15 December 2016

NOTIFICATION OF EXHIBITION - TOYOTA SPARE PARTS WAREHOUSE AND DISTRIBUTION CENTRE (SSD 7663)

I refer to the Notice of Exhibition dated 14 November 2016 inviting Council comment on the development application (DA) for the Toyota Spare Parts Warehouse and Distribution Centre, located at Lot 12 in DP 1178389, in the Penrith City Council local government area.

**DEVELOPMENT APPLICATION**  
 Drawing Name:  
**Landscape Site Plan**

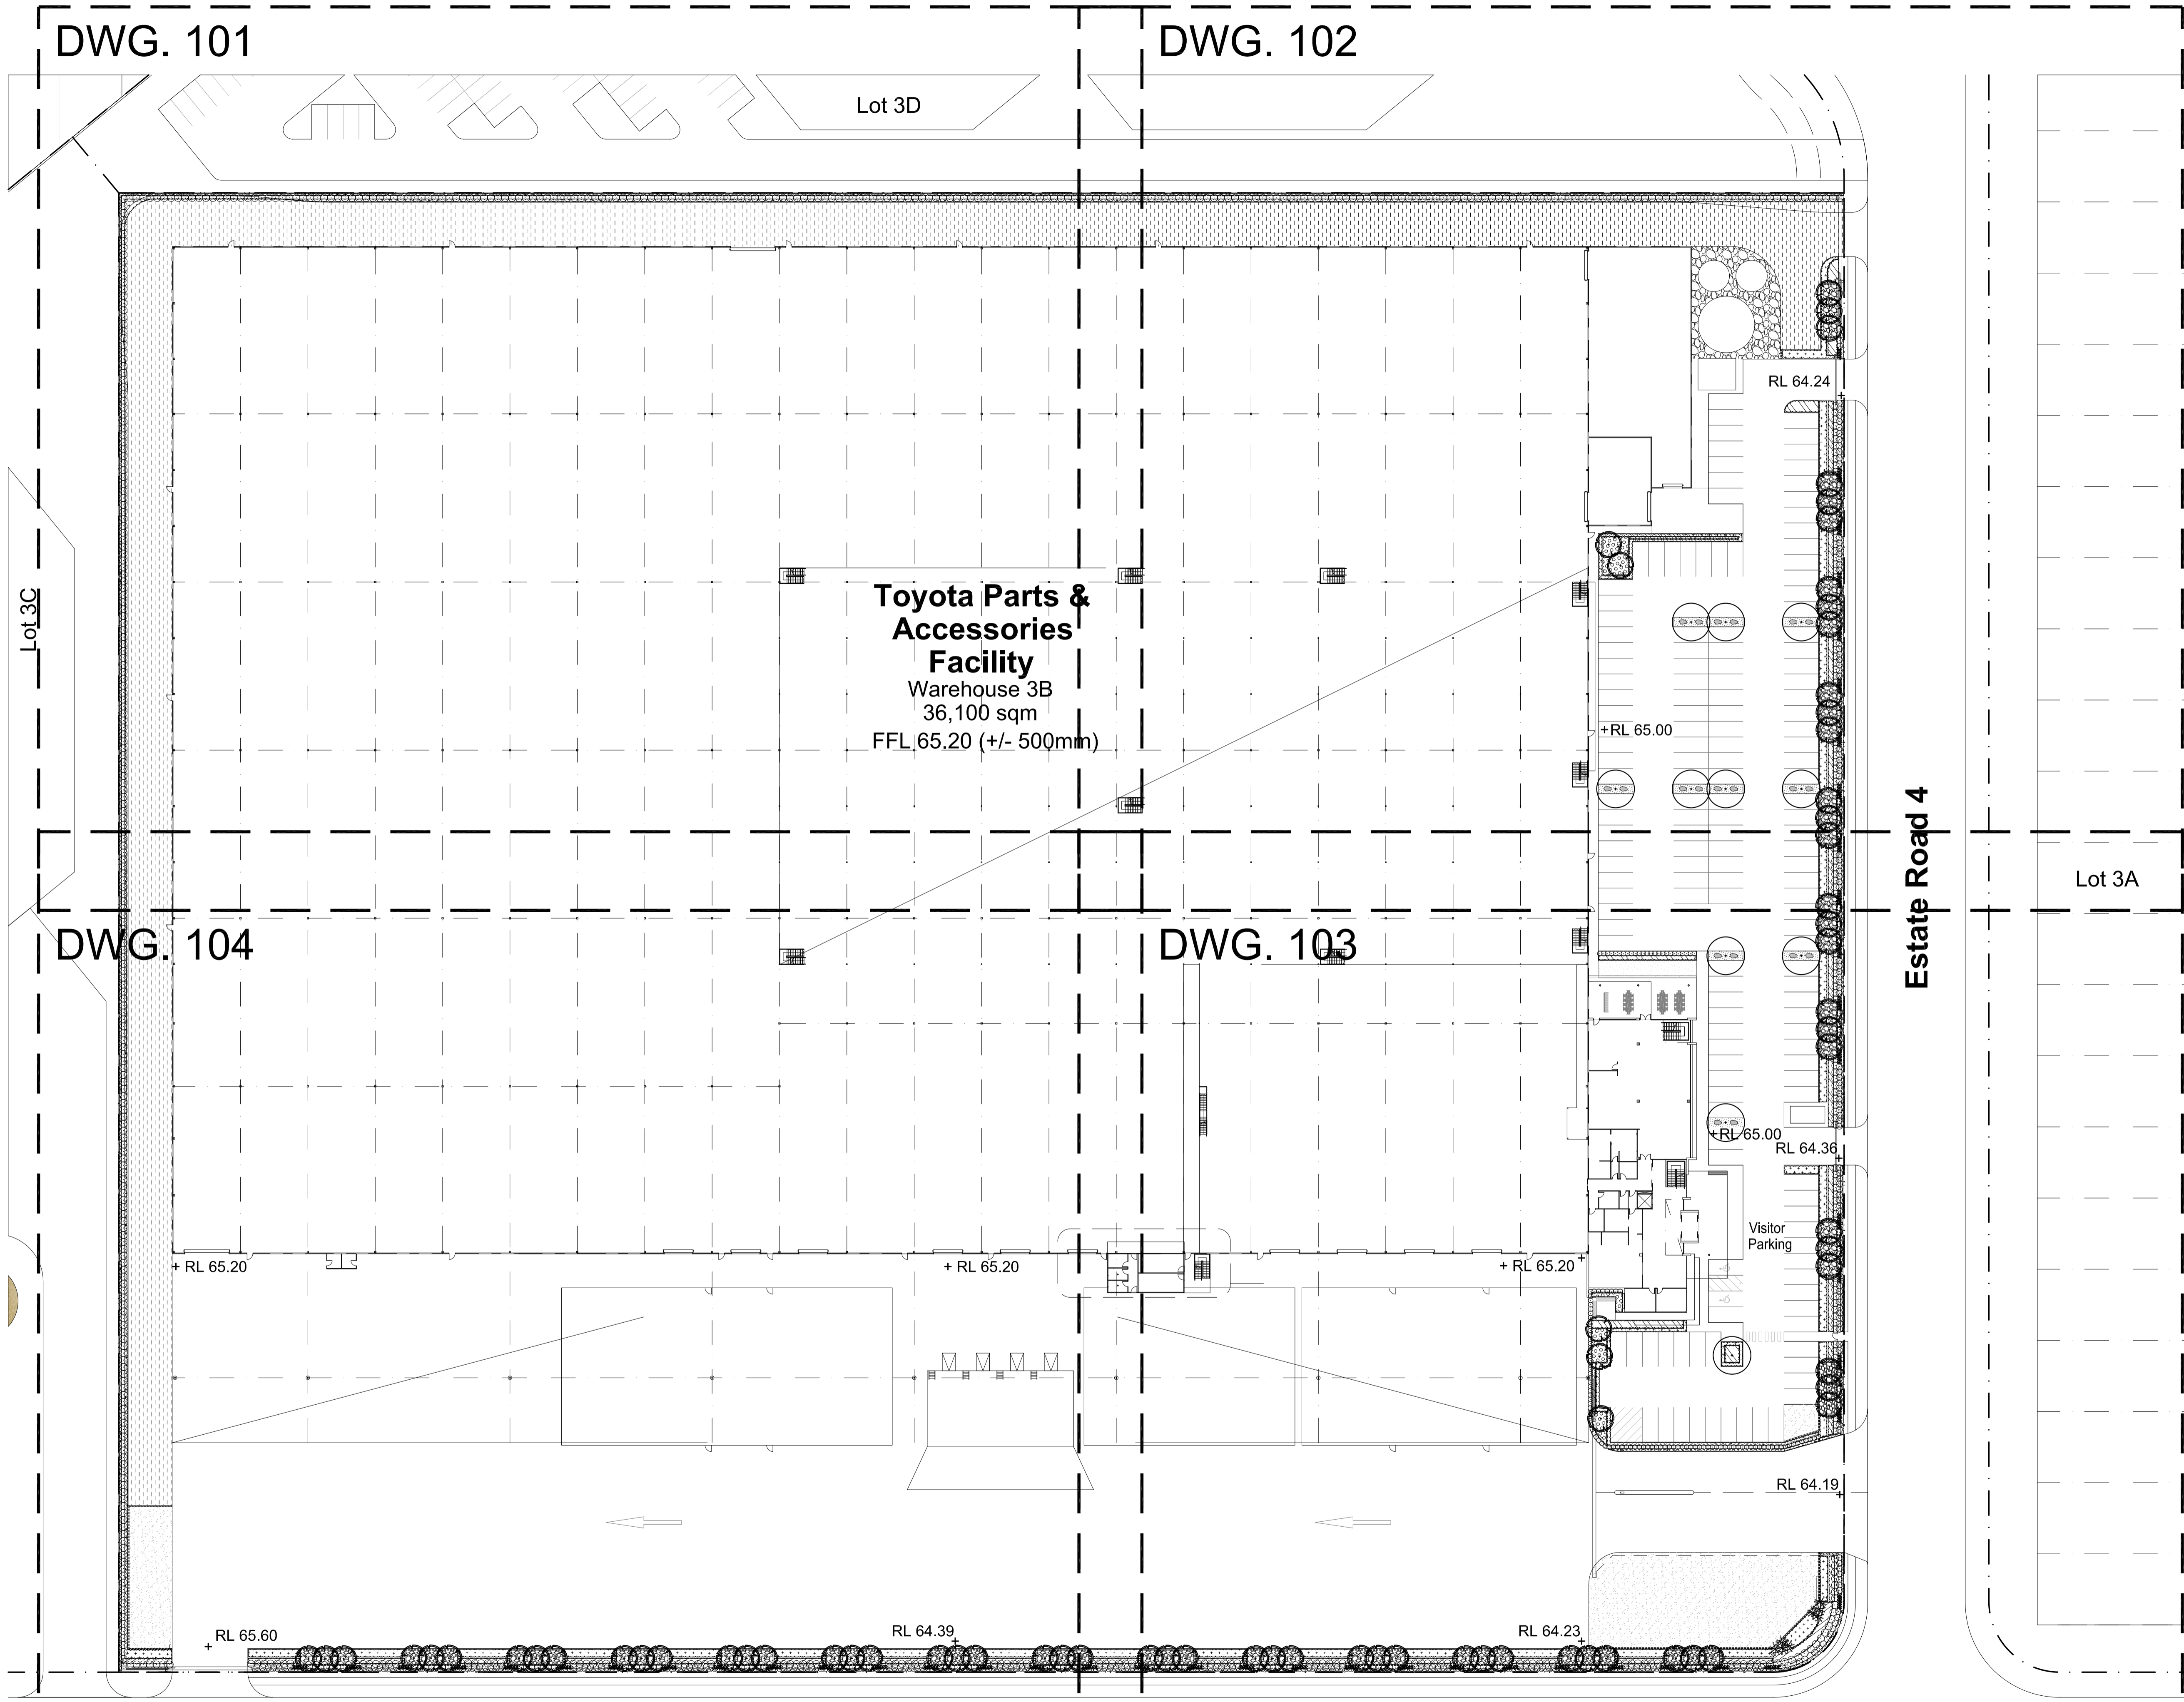
Accordingly it is considered that a minimum the extent of landscaping along this eastern boundary should be increased beyond the minimum outlined in the Oakdale South guidelines. It is suggested that the landscape width for this eastern boundary be increased to match the 15 m setback to any road required by the Erskine Business Park Section of Council's DCP. This increased landscape setback does not appear to impact on any site operations including access and egress from the recessed loading docks.

The batter slopes at the western and southern boundaries straddle the proposed lot boundaries. Additionally given that they are proposed at a slope of 1:3 they should be fully vegetated given that mowing this gradient will be difficult.

The perimeter road should also be setback 2.5 m for its entire length as per the site specific controls included in the Oakdale South SSD approval. The perimeter road should not encroach on the landscape setback at any point including the south-western corner of the site.

02 EAST ELEVATION
WAREHOUSE 3B

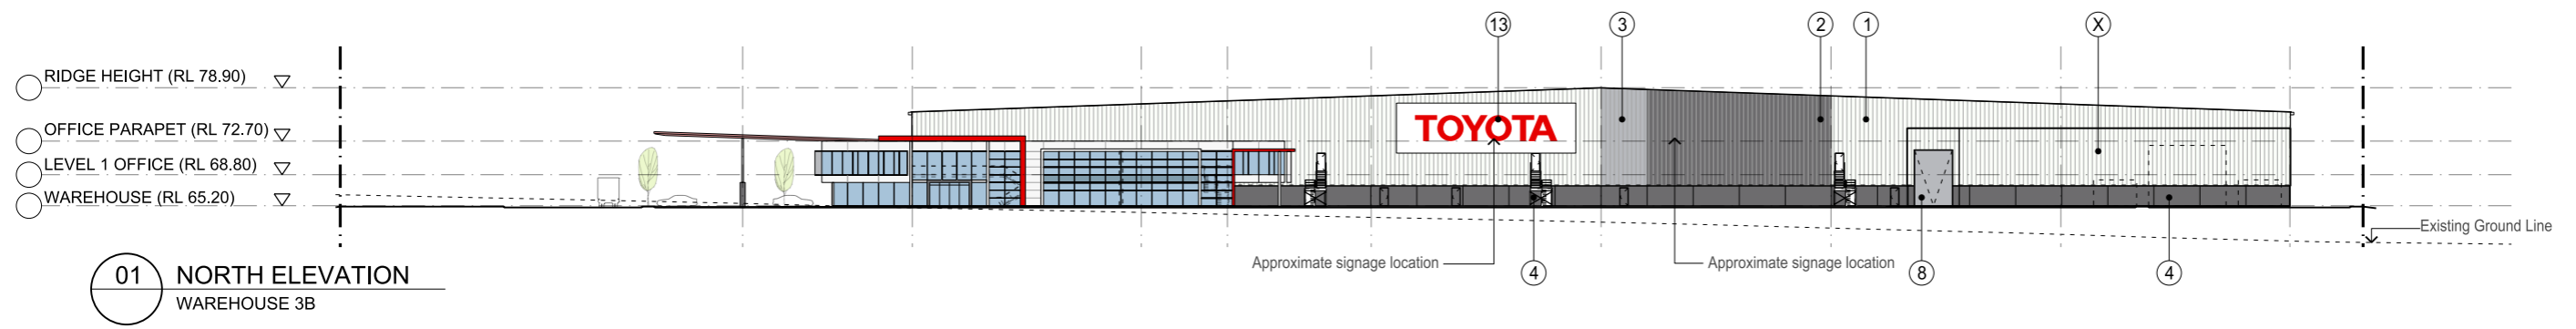
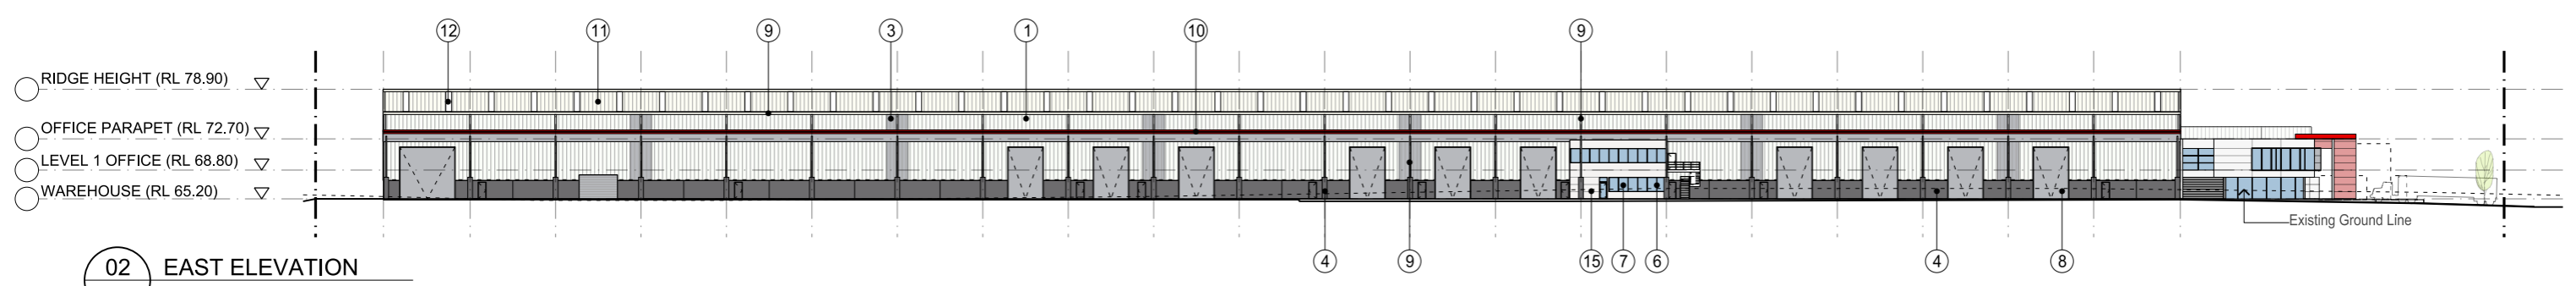
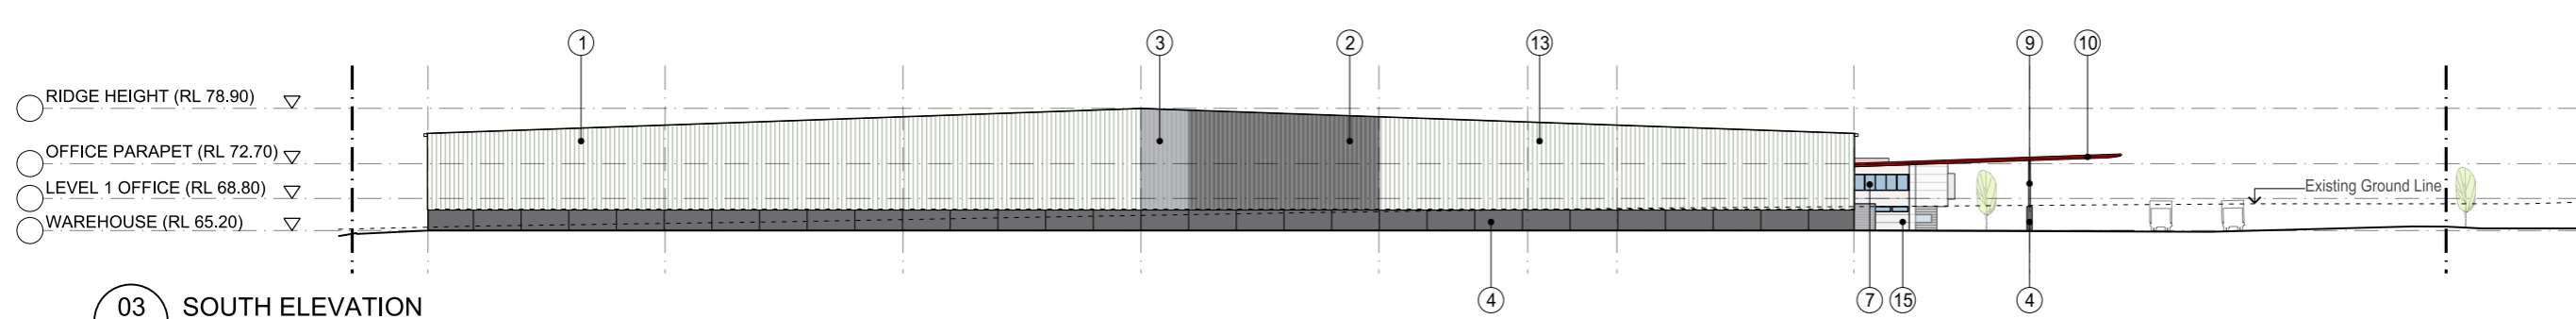
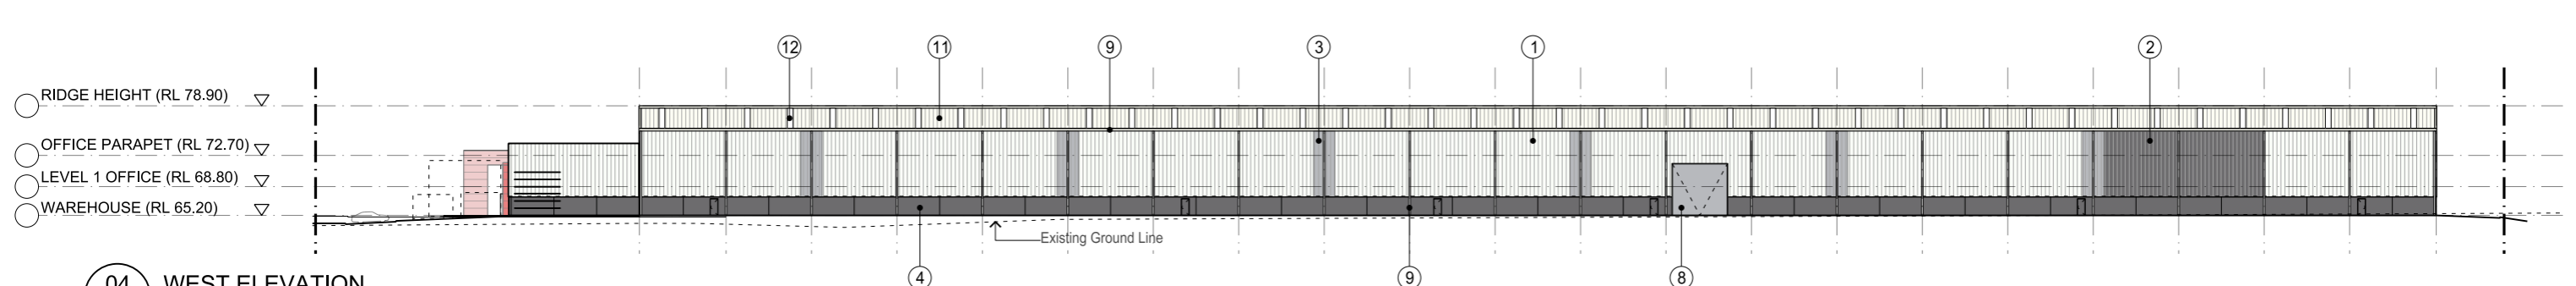
Whilst it is acknowledged that the proposed development has been designed according to Toyota's detailed requirements and has been orientated towards Estate Road 4, the proposed development shows little regard for any presentation to its frontage to Estate Road 1.

S7 Illuminated box lighting lettering

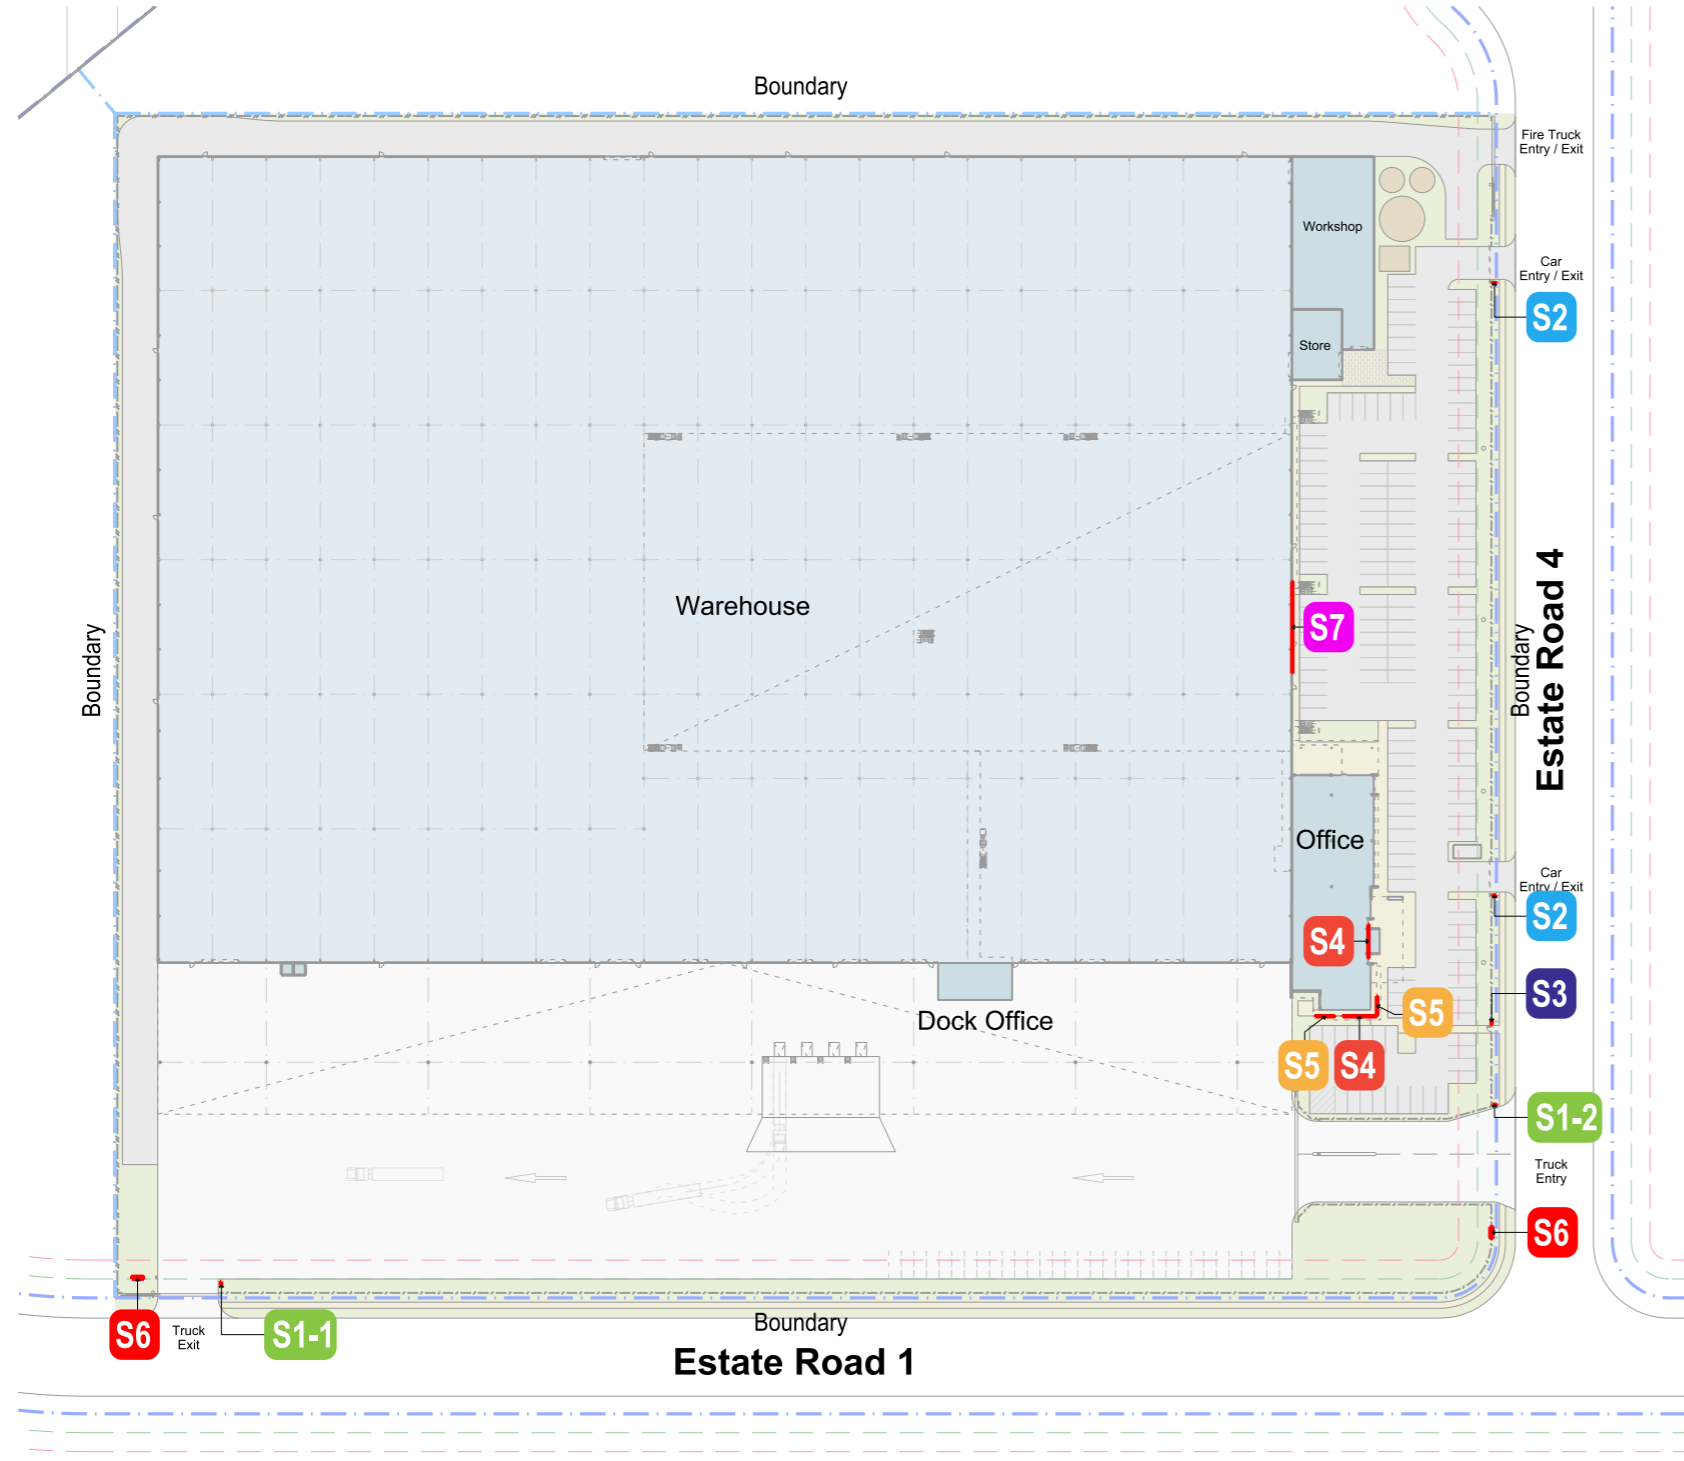
The amount of business identification signage proposed is considered to be excessive, particularly given that the site will not be attracting retail customers to the site. Accordingly the proposed development should comply with Council's DCP controls for signage, particularly the control which outlines that industrial and business park uses are only *"permitted one pole or pylon signs with the maximum height not in excess of 7.0m."*
